14 April 2022

Submission to the Department of Planning and Environment –SSD-30923027 – Lot 1 DP 1274322 Eastern Creek Drive, Eastern Creek (Applicant: Charter Hall Holdings Pty. Limited)

Figure 2 – Proposed Site Plan

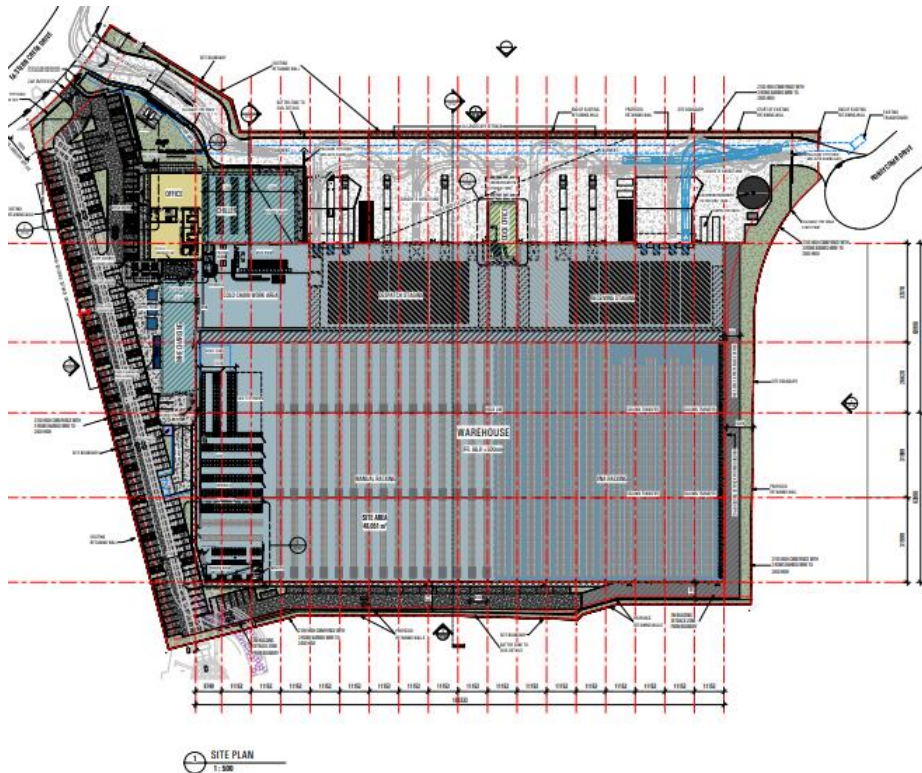
Inconsistencies have been identified with the DA's landscaping design along the northern boundary of the site, and the location of the fire access track also needs clarification.

Along the northern boundary of the site, it is unclear whether the site will be fully landscaped, as per the Site Proposal Plan (Figure 4 of the Request for SEARs letter submitted by Willowtree Planning), or partially landscaped with a fire access (spray sealed surface) also running along the northern side and part of the eastern boundary, as per the Landscape Plans and Architectural Drawings. Consistent site design throughout all submitted plans is required to ensure that development of the site matches the associated plans.

Figure 5: Site Plan from the Architectural Drawings highlighting the inconsistencies with regard to the fire access track

We propose that the development should not be approved until owners' consent is obtained from the landowners of Lot 271 DP 1198561 and Lot 2 DP 1274322 as the proposed development encroaches onto their land. Further, a consistent site design should be established, particularly with regard to the location of the fire access track and associated landscaping. The registration of the proposed extension of Honeycomb Drive is also required to be approved by Blacktown City Council prior to the approval of this DA.
